From: Laura Gibbons
Sent: 14 February 2019 13:06
To: Planning.Responses
Cc: Anita Gardner
Subject: RE: Planning Consultation on: A/175/18/PL

Engineers Comments Regarding Surface Water Drainage

Description of Works: Temporary car park extension.

Figure 4: Proposed site layout for temporary car park extension

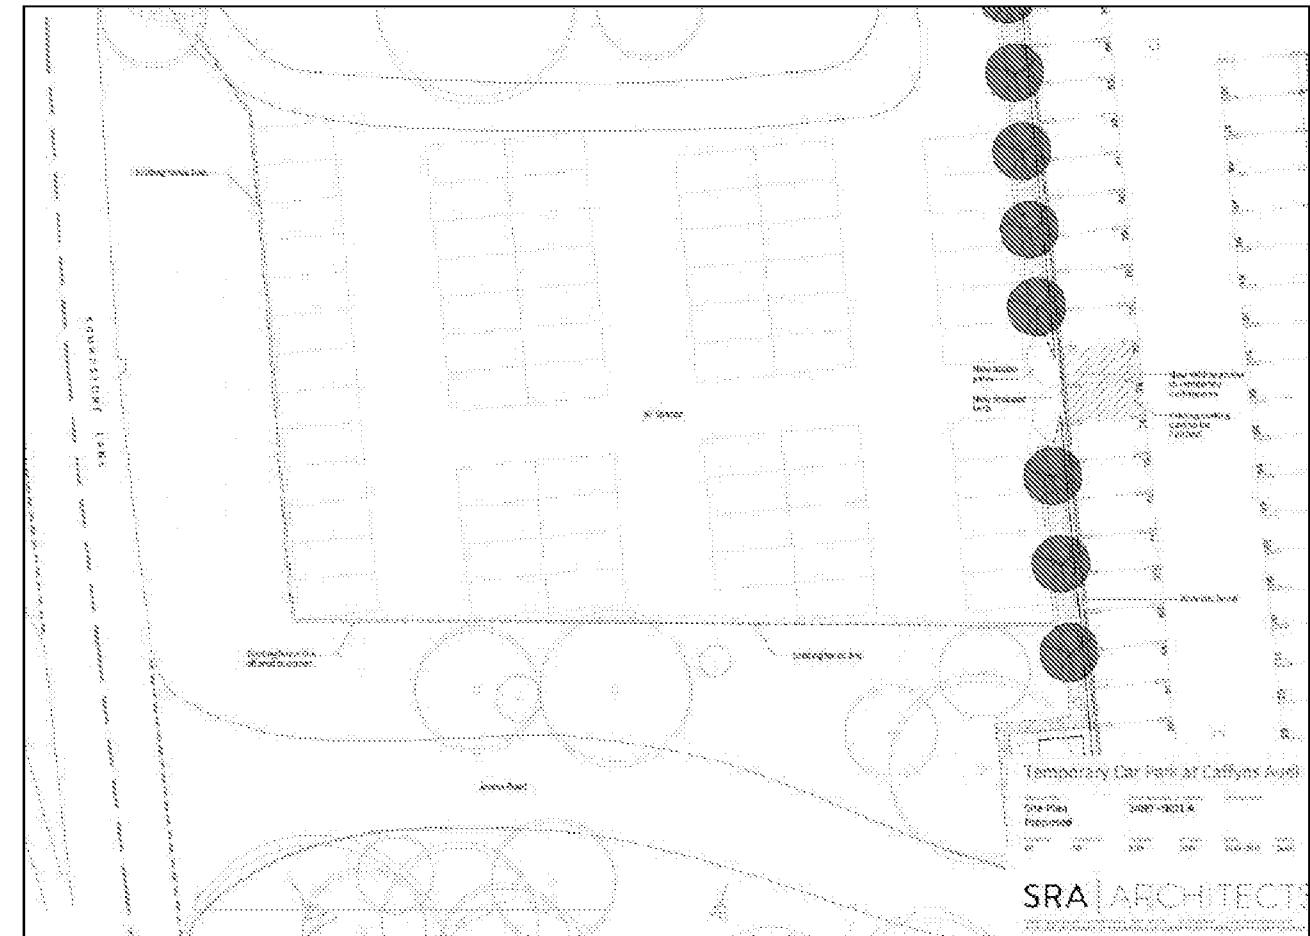
The application states that the car park extension will be formed from permeable surfacing, no further details were provided. We require construction detail drawings to be submitted detailing the materials to be used. The application also references groundwater monitoring and infiltration testing completed in close proximity to this application. Due to the proximity of these investigations we do not require additional winter groundwater monitoring. However, we do require shallow infiltration testing to be completed in the winter. This is because the testing completed nearby was at far deeper depths than those typically proposed for permeable car surfacing.

If you are minded to approve this application please apply the following condition to ensure the development is adequately drained: "Development shall not commence, other than works of site survey and investigation, until full details of the proposed surface water drainage scheme have been submitted to and approved in writing by the Local Planning Authority. The design should follow the hierarchy of preference for different types of surface water drainage disposal systems as set out in Approved Document H of the Building Regulations, and the recommendations of the SuDS Manual produced by CIRIA. Winter Percolation testing to BRE 365, or similar approved, will be required to support the design of any Infiltration drainage. No building / No part of the extended building shall be occupied until the complete surface water drainage system serving the property has been implemented in accordance with the agreed details and the details so agreed shall be maintained in good working order in perpetuity."
